CITY OF PORTLAND, MAINE

May 27, 2015

Project Name:	Mixed Use Retail and Office Building	Project ID:	2014-065
Address:	16 Middle Street	CBL:	020 F002001
Applicant:	Nathan Bateman		
Planner:	Shukria Wiar

Mixed Use Retail and Office Building
16 Middle Street
Level III site Plan and Subdivision
2014-065
Bateman Partners, LLC Applicant

PROJECT	16 MIDDLE STREET PORTLAND, MAINE
SHEET TITLE	CONSTRUCTION MANAGEMENT PLAN
CLIENT	BATEMAN PARTNERS LLC

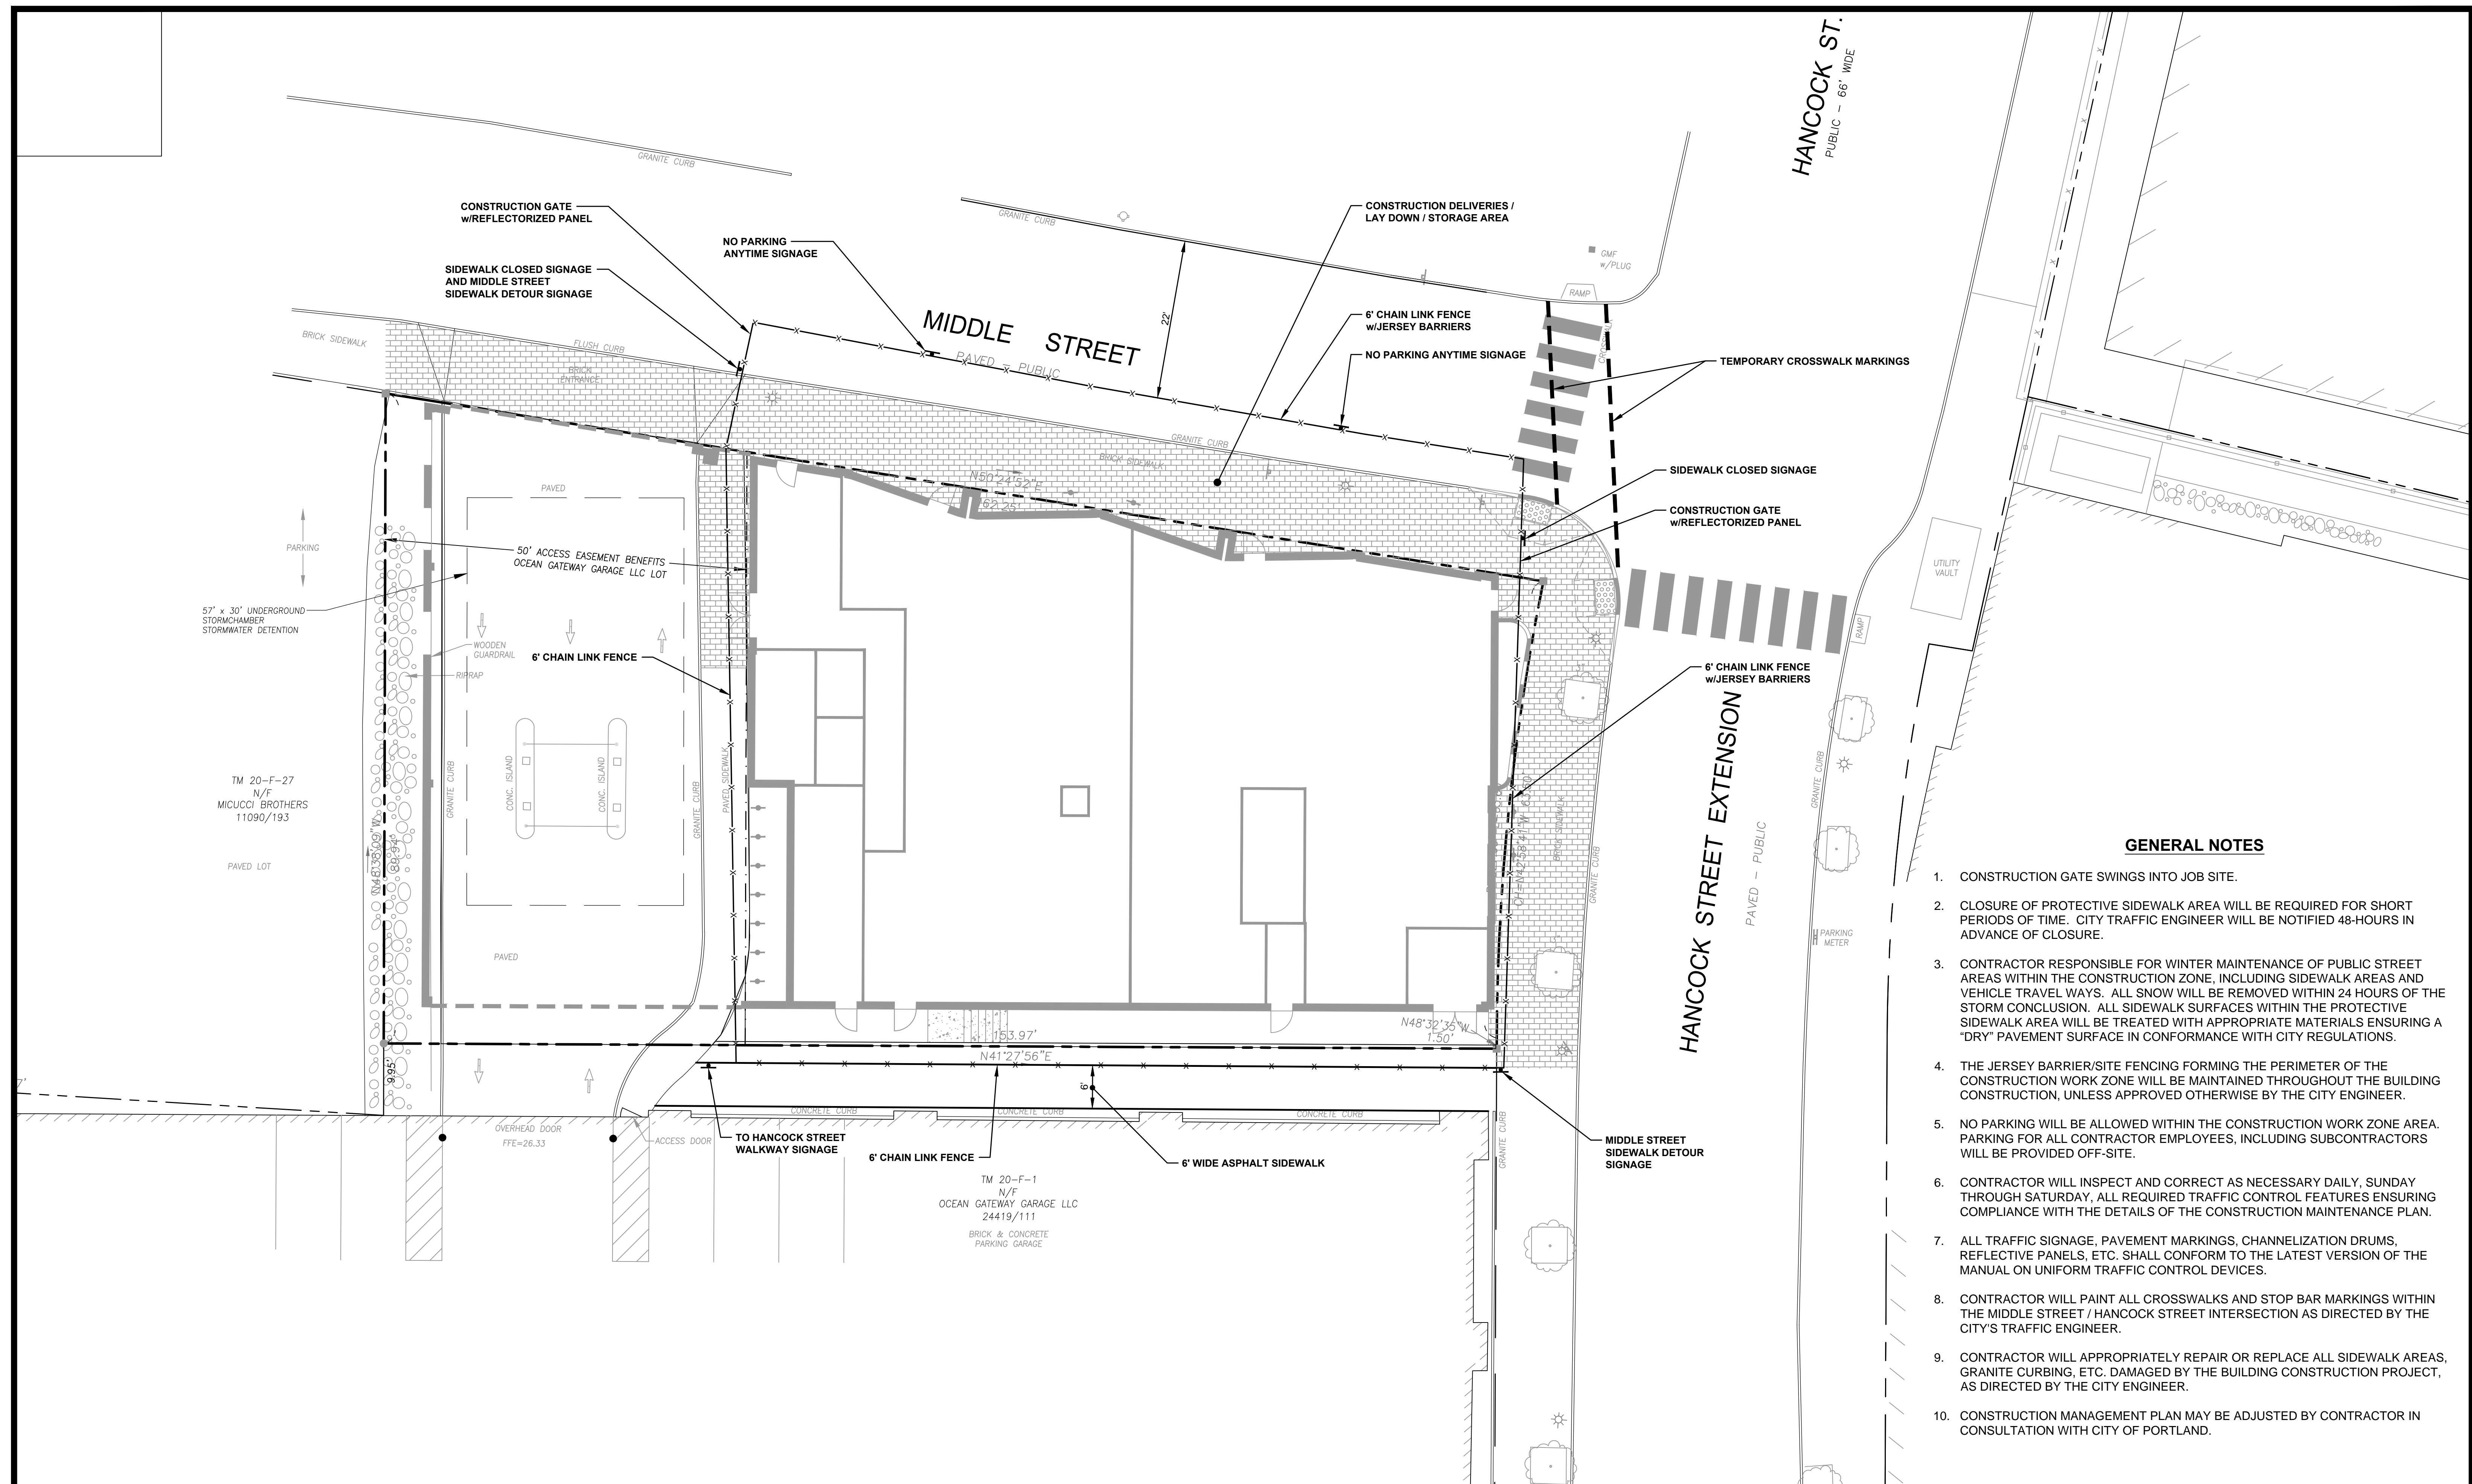
3. The applicant shall be responsible for conducting an annual survey and the Traffic Demand Plan be adjusted as necessary.
4. The Construction Management Plan shall include the final details of the temporary barrier protected sidewalk to be approved by the Department of Public Services prior to issuance of a building permit. This temporary sidewalk shall be ADA compliant and shall have MUTCD compliant signage.
